24th January 2022

Application No: Y/127/21/RES
Site Address: Land at Bilsham Road Yapton
Description of works: Approval of reserved matters (appearance, landscaping, layout and scale) following the grant of Y/91/17/OUT for 250 No dwellings with associated parking, road/footway/cycleway provision, open space, landscaping, surface water attenuation & ancillary works (resubmission following Y/152/20/RES). This site is not CIL Liable as in Yapton Strategic Site.

OWPC43613

drawing title
Open Space Provision

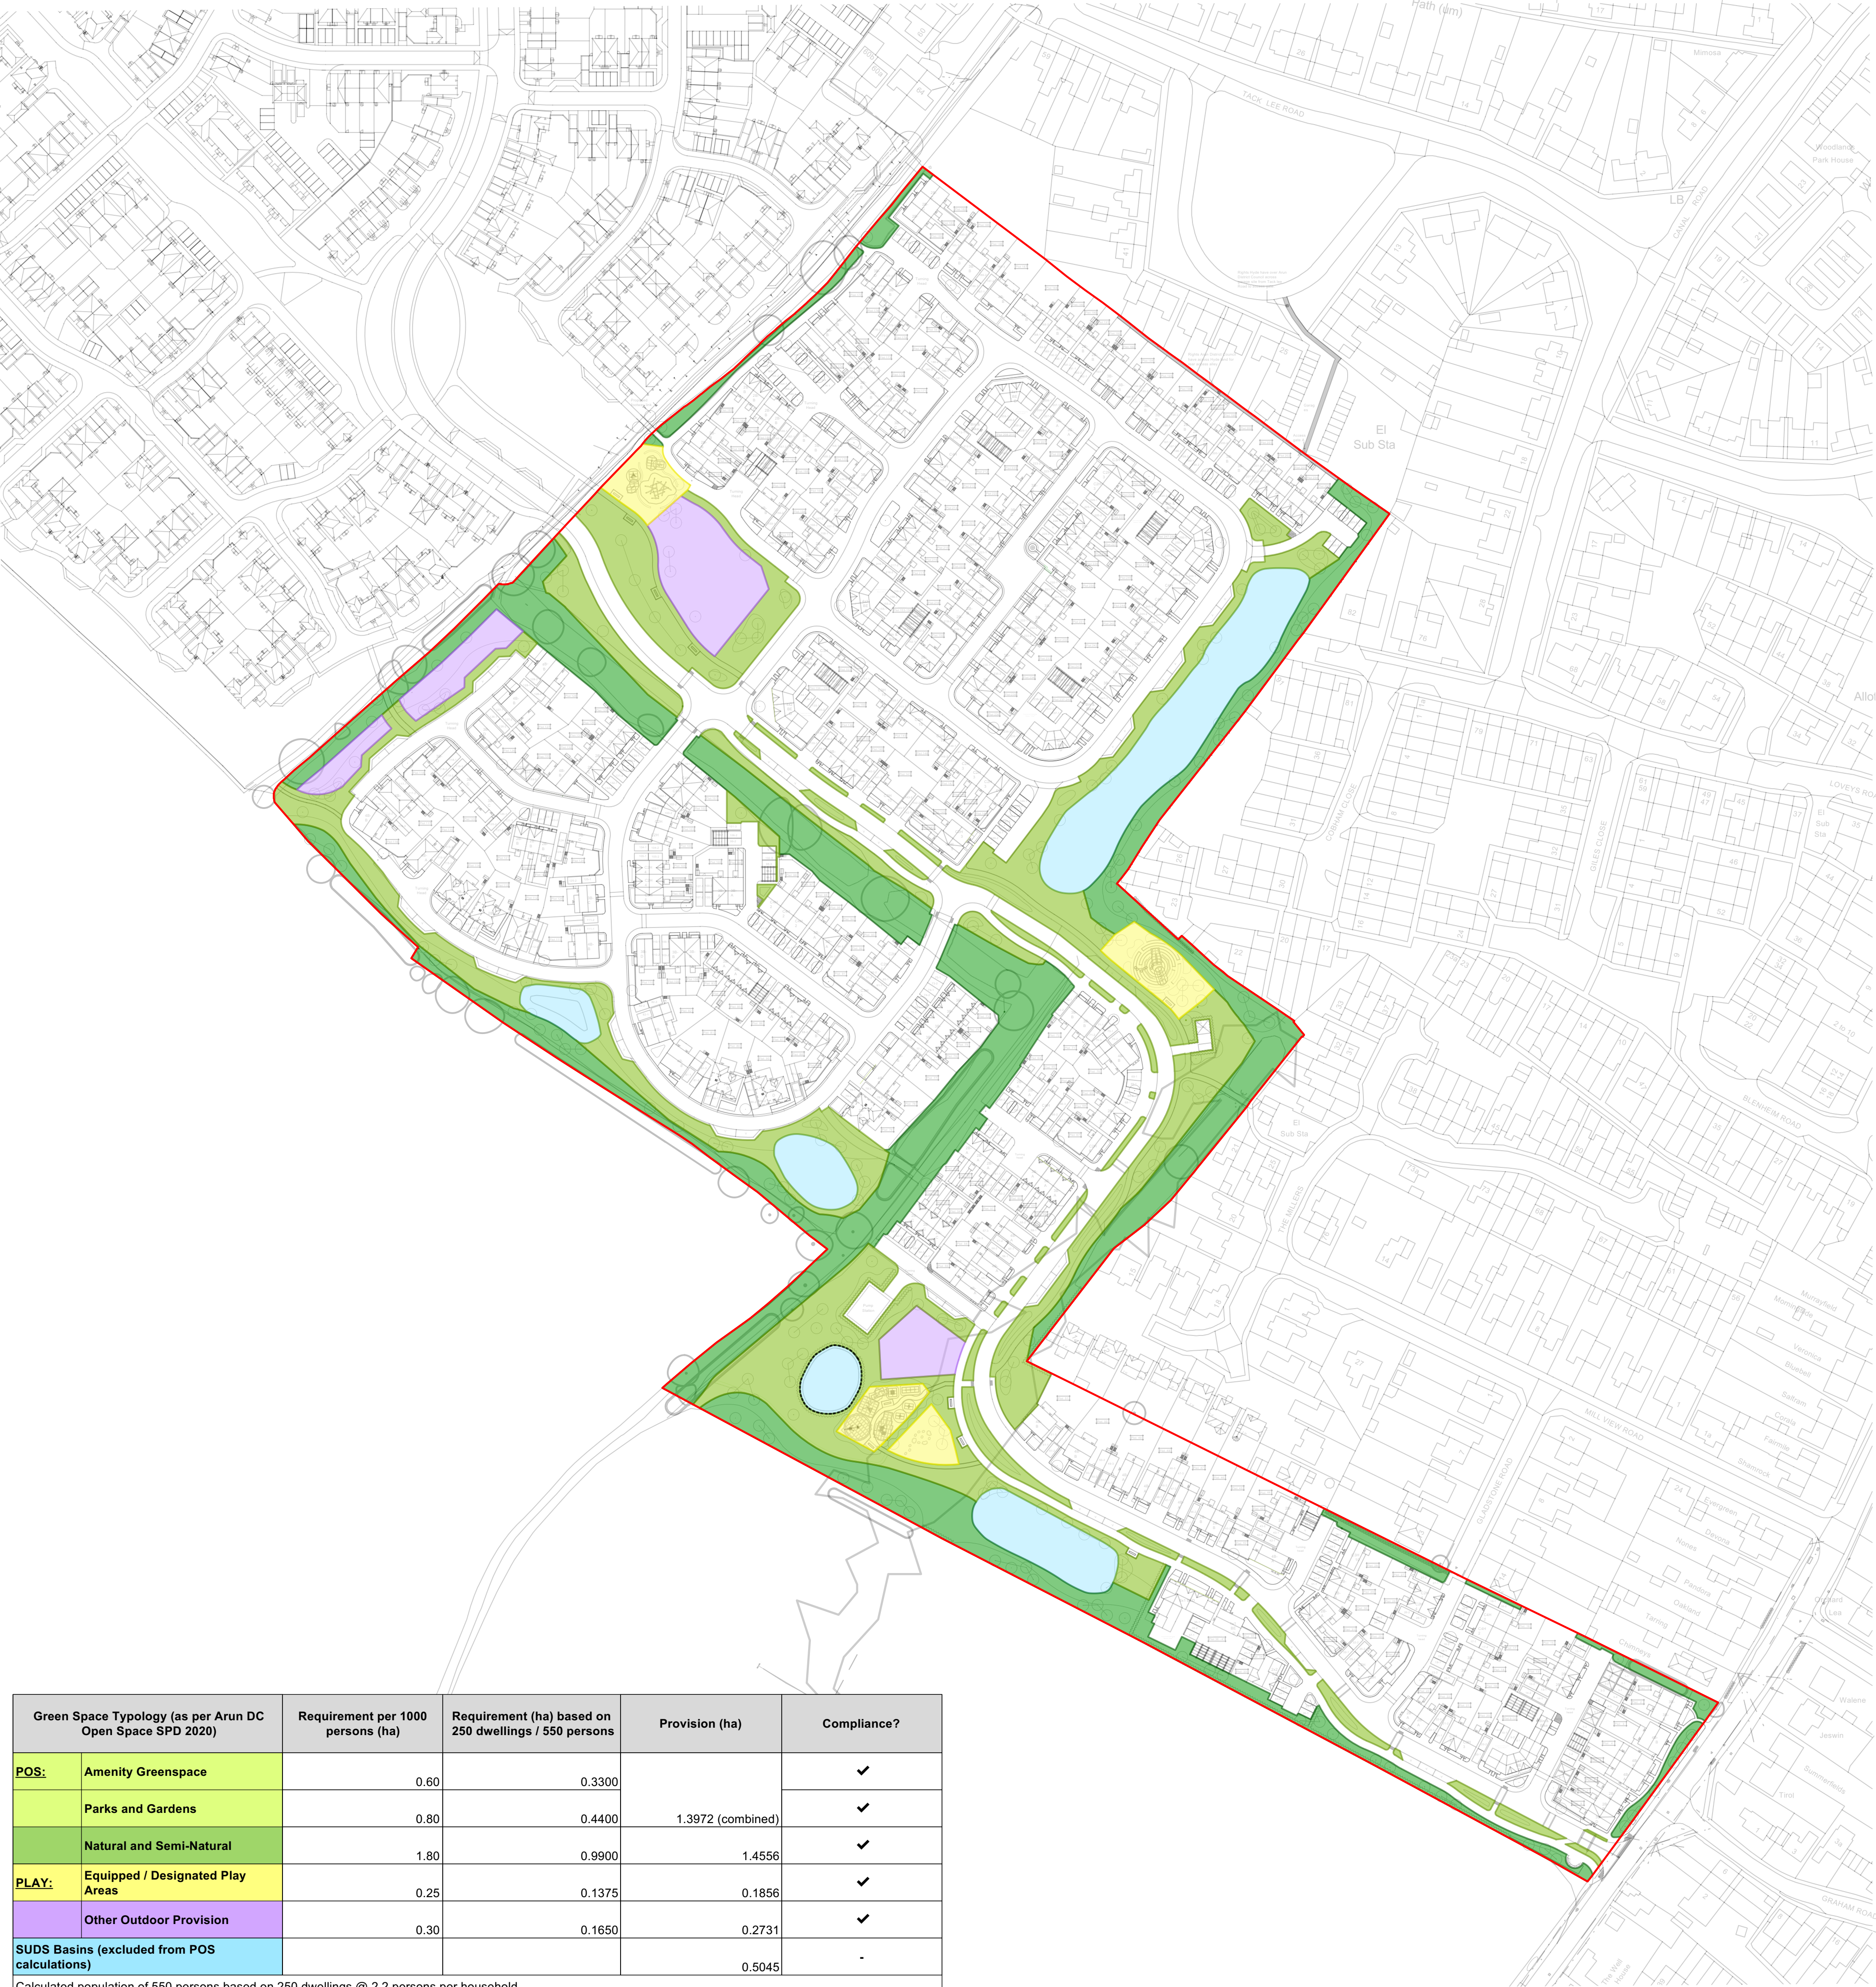
However, YPC are disappointed to note that the applicant continues to fail to address YPC's concerns regarding the loss of amenity space to water collection pools. It is clearly illustrated that much of the open space is lost to rain water and run-off during wet periods. YPC believe that the applicant must ensure that the site is not only fit for today's residents but those in the future. Evidence clearly shows an increase in extreme weather events, notably higher volume rainfall during shorter periods of time resulting in collection pools becoming more akin to ponds than temporary water collection features.

YPC would therefore suggest that the applicant ensure that a more robust engineering solution is used to substitute the collection pools thus enabling the amenity space to be useable the whole time and not simply when dry weather prevails.
